Address: Royal Oak Inn, 19 Town Gate Holmfirth HD9 3UX

Application number: 2022/92799	
What is the application for?:	Erection of extensions, conversion of existing attached barn to living accommoda
Address of the site or building:	17, Town Gate, Upperthong, Holmfirth, HD9 3UX
Postcode:	HD9 3UX

User comments

Number
4416-06-05a
Date
04/2023
Scale @ A1
As Marked

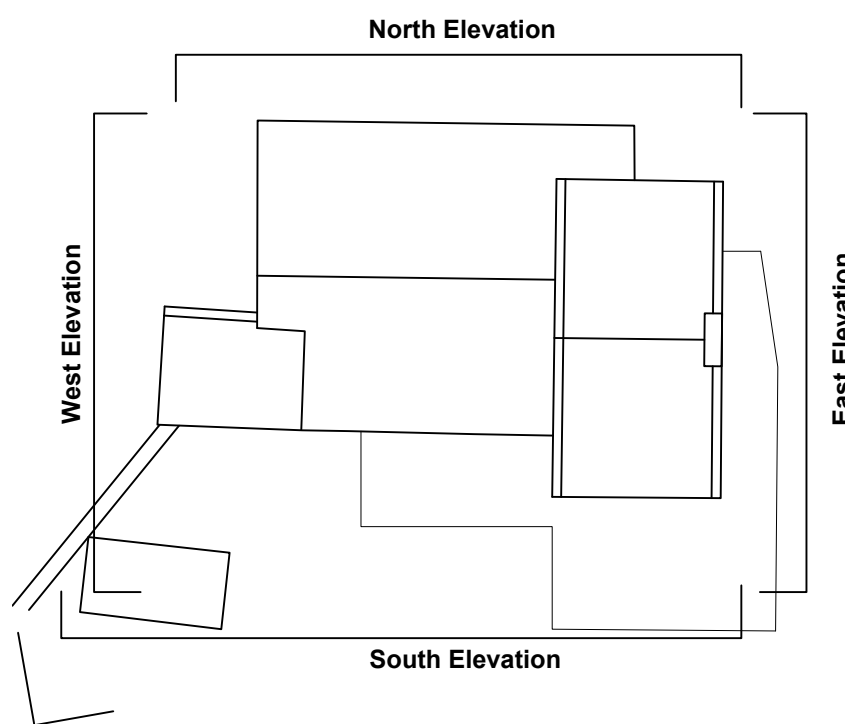
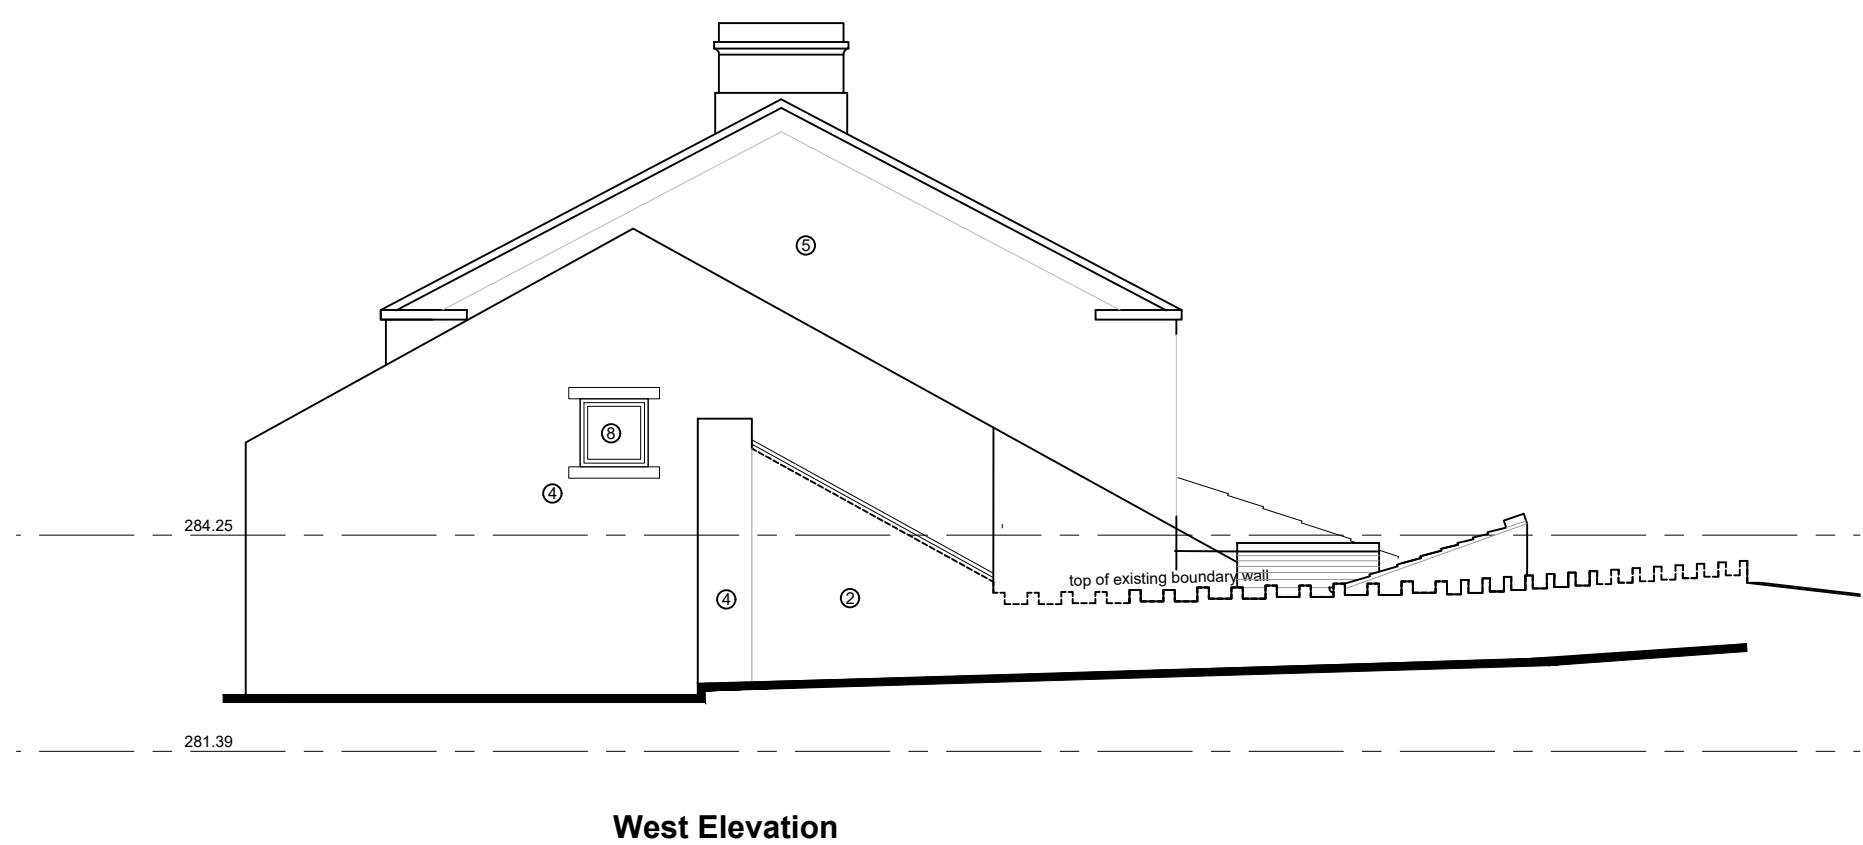
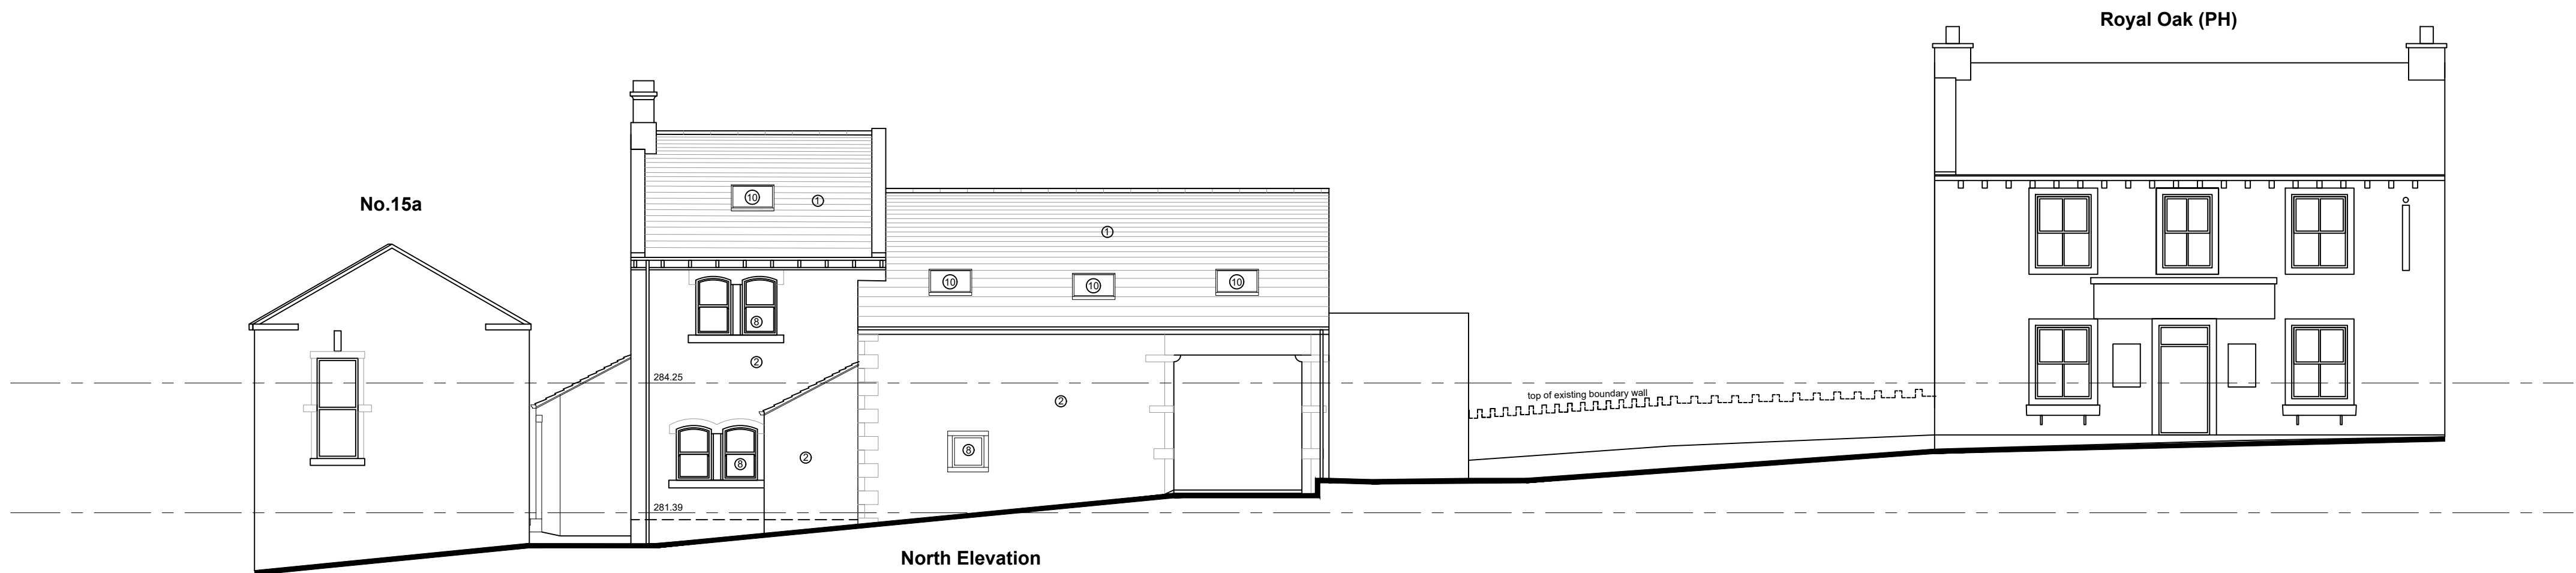
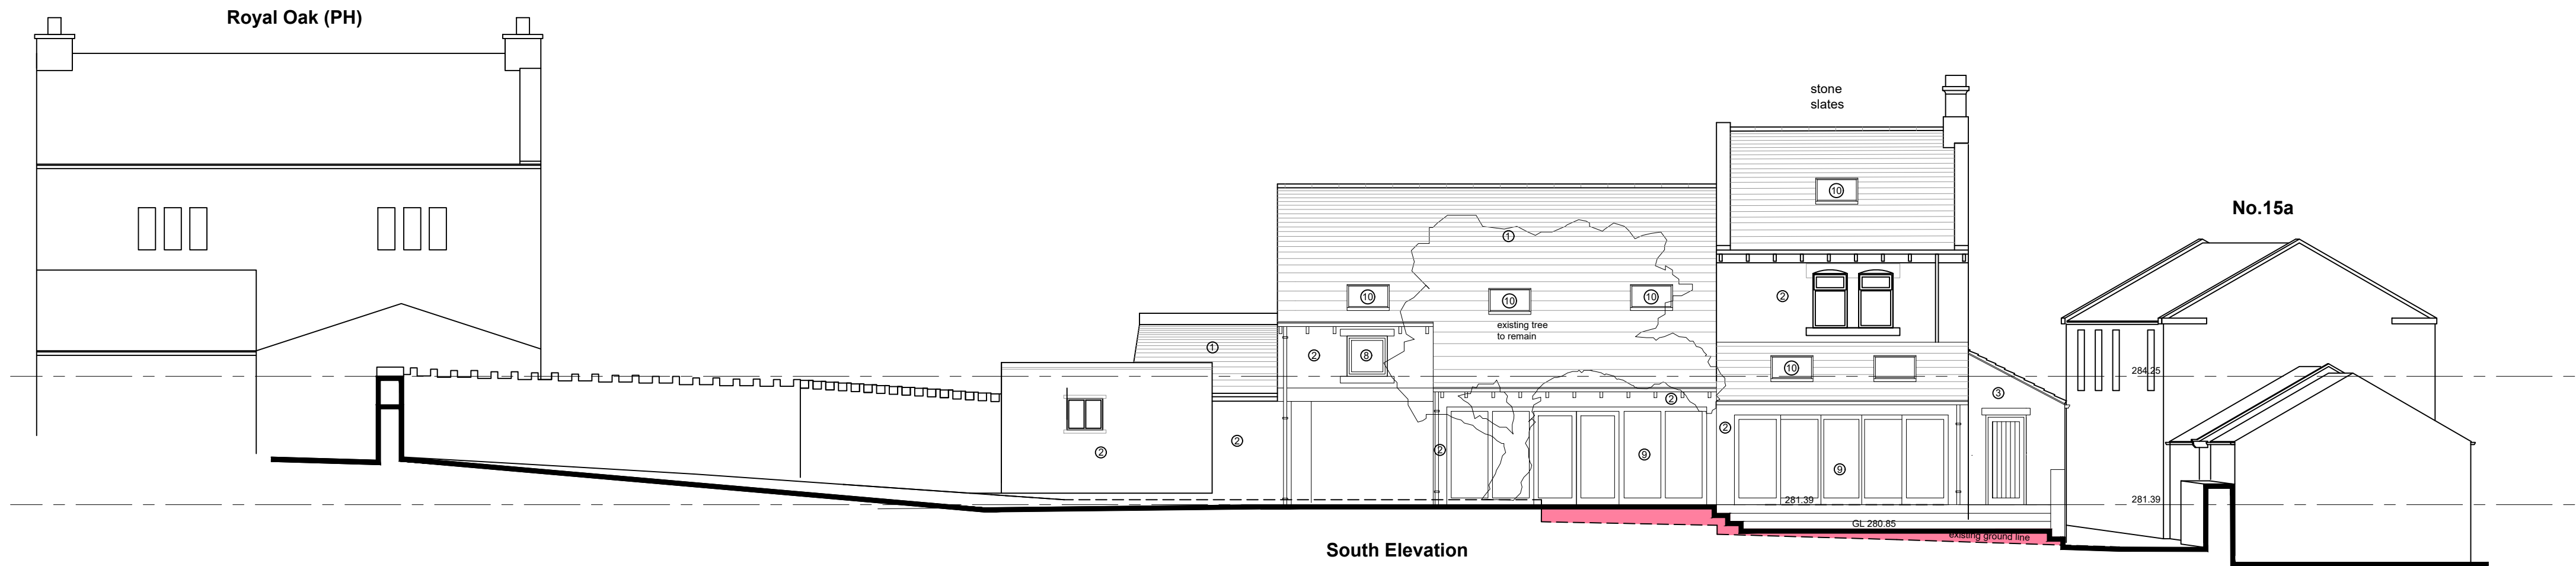
I also feel that the plans submitted for the rear elevation of the property to be utterly unsuitable. Putting aside any feeling on good taste, and architectural merit, which having studied the application, could be argued. The materials suggested are so far removed from the traditional materials and design that are required to be used in a conservation area. The proposed ground to eaves expanse of wood and glass is certainly not traditional, and certainly not in keeping with the locality. I would not wish to be living in properties to the south of No 17. Given the path of the sun, the solar glare it will create will be unbearable.

As with the front elevation, whilst it currently seems to be the fashion, the use of timber is not a traditional external building material. Also the proposed garage, forgive me, but I am not aware historically of any local farmers, or anyone for that matter, using sedum roofs for any buildings. I may be wrong.

That then brings me to the question of the proposed wall on the shared boundary between The Royal Oak and the applicant. Whilst it is often stated that no one has a right to a view, it could be countered that no one has a right to block a view.
